LATE SCOPING CONSULTATION RESPONSES

From: Planning [mailto:Planning@chilternsaonb.org]
Sent: 02 August 2018 21:55
To: Expansion of Heathrow Airport (Third Runway)
Subject: RE: TR020003 - Expansion of Heathrow Airport (Third Runway)

Our more detailed comments and concerns on the Scoping Report:

Title
 Figure 13.1: Landscape and visual considerations

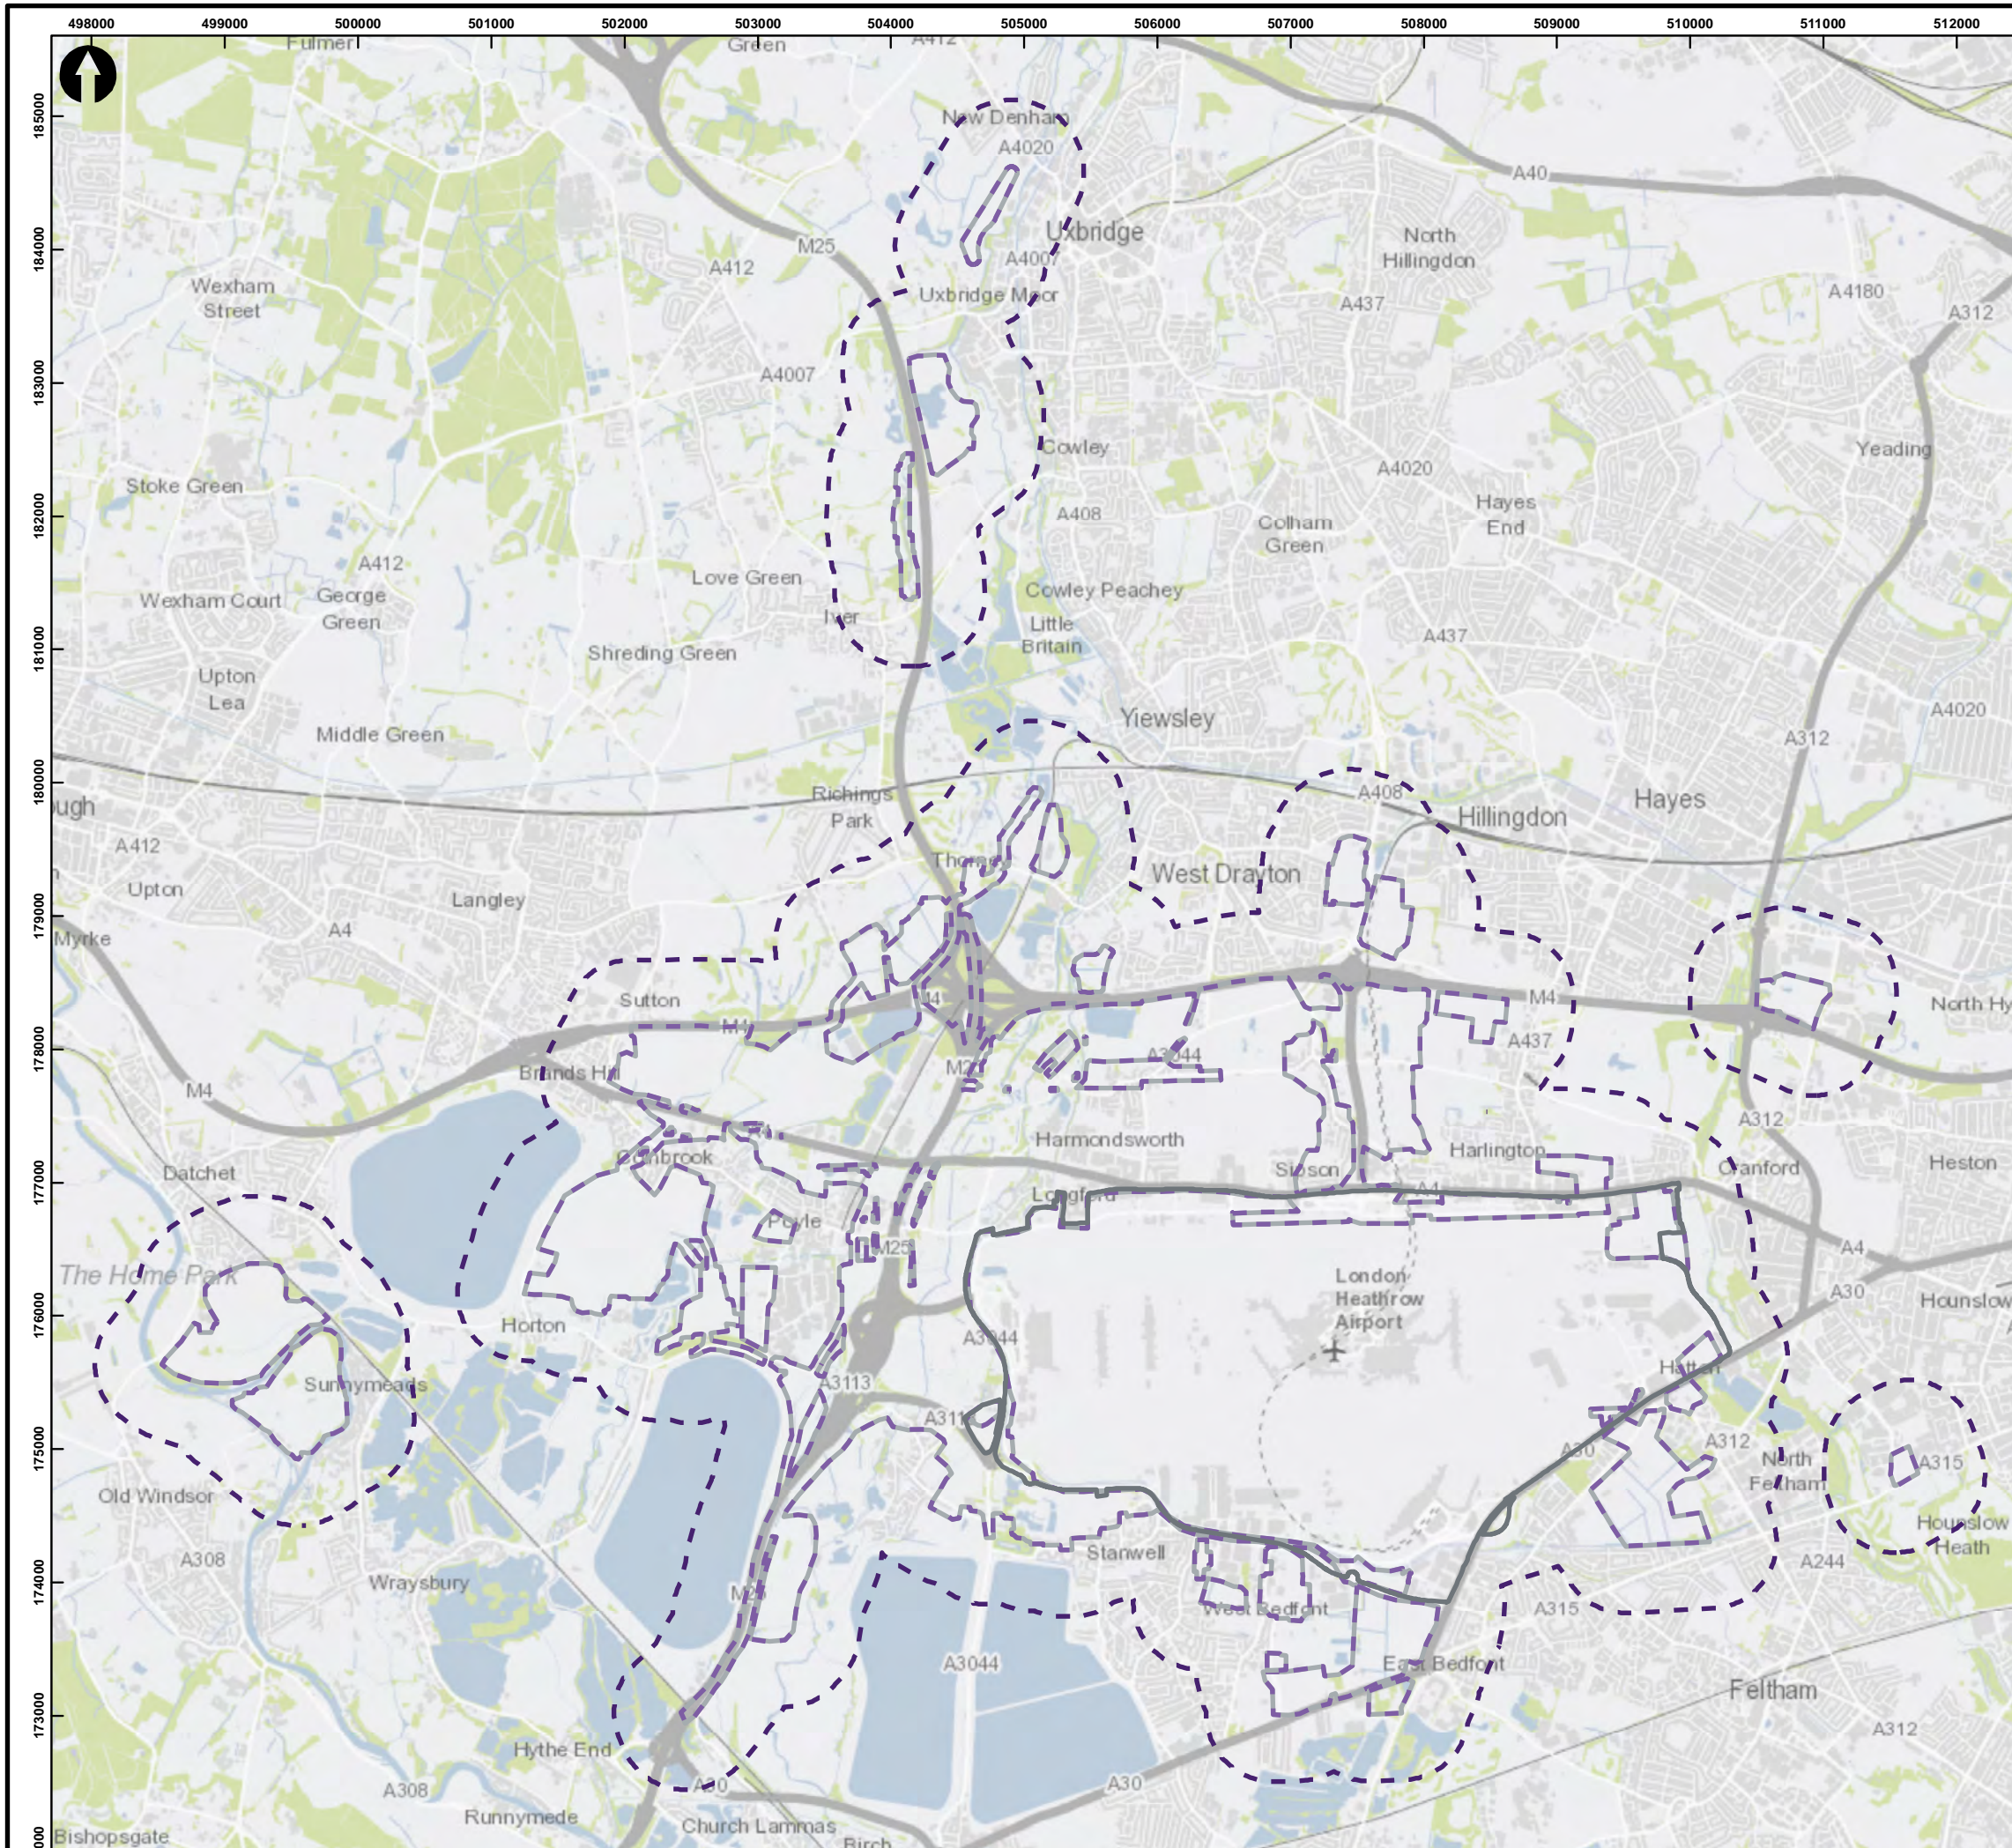
- Ch 13: Landscape and visual amenity: is the proposed study area (5km beyond maximum landtake) wide enough? Might Heathrow be visible enough from some locations to be considered to be in the setting of the AONB?
